KITTITAS COUNTY DEPARTMENT OF PUBLIC WORKS

MEMORANDUM

TO: All Staff
FROM: Public Works Plan Review Team
DATE: April 25, 2024
SUBJECT: BL-24-00003 Hanson

SHEET 1 OF 2

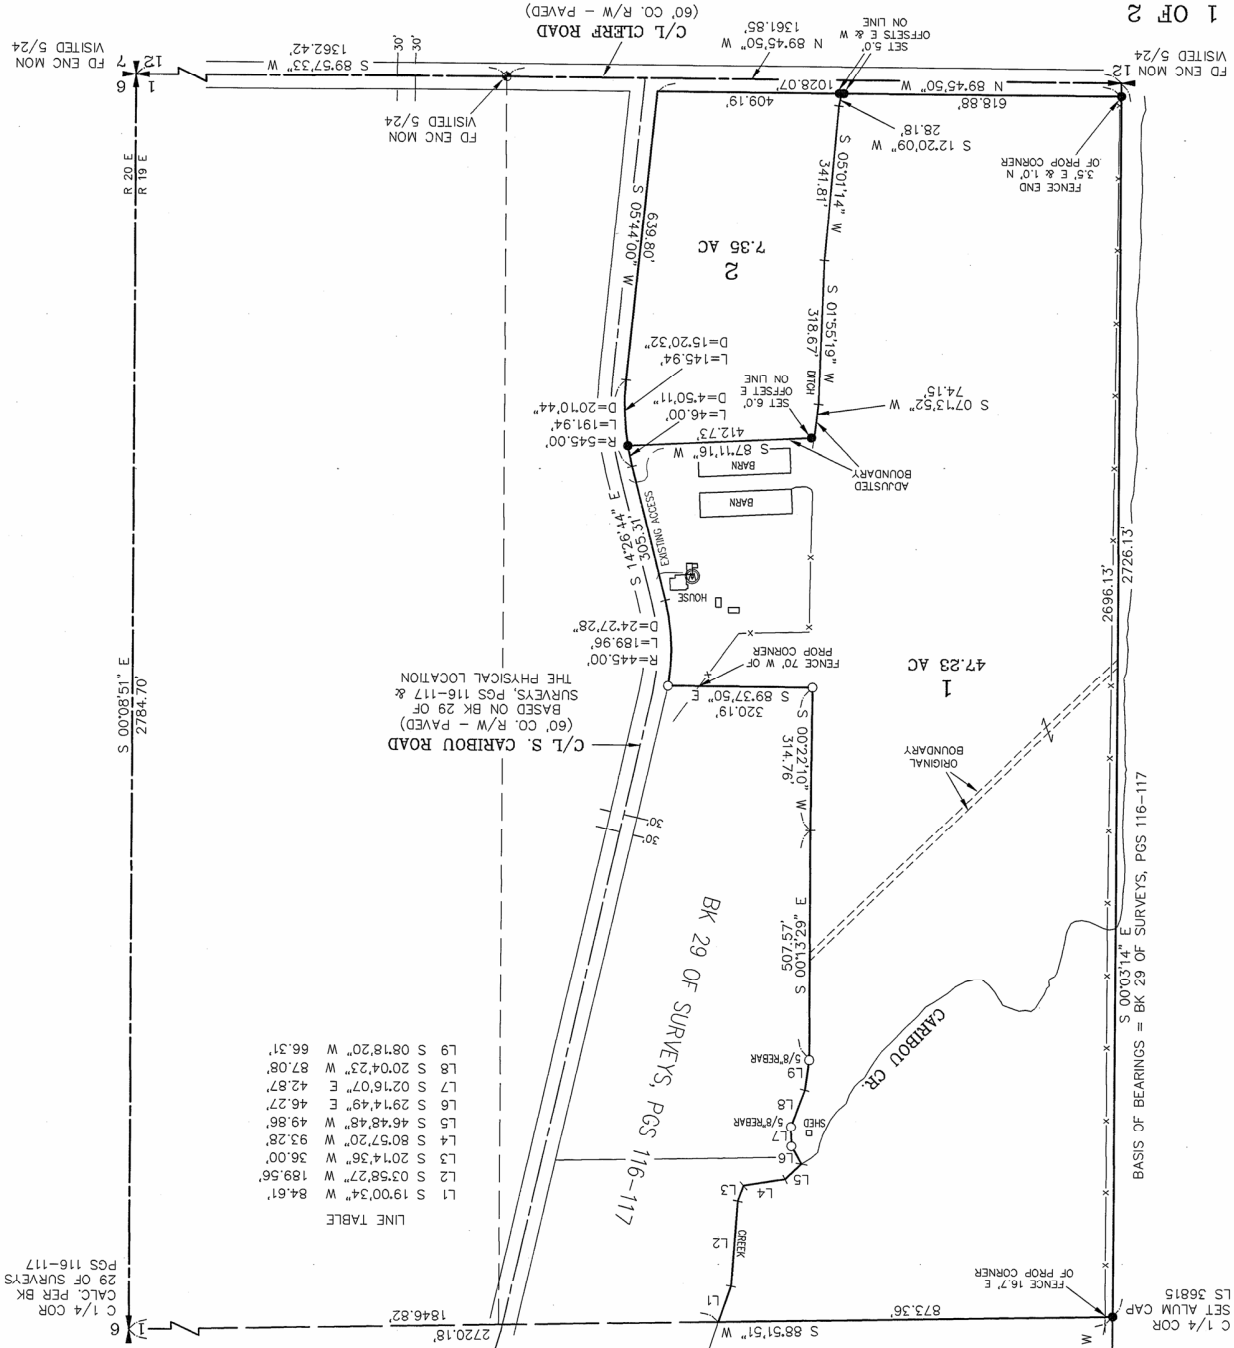
SURVEY	<p>As the application does not contain a survey, comments are reserved until final. (JT)</p> <p>UPDATE 06/03/2024 There are no required changes needed to the BLA Survey map. (JT)</p>
TRANSPORTATION CONCURRENCY	No transportation concurrency management application is required for this project. (KAH)
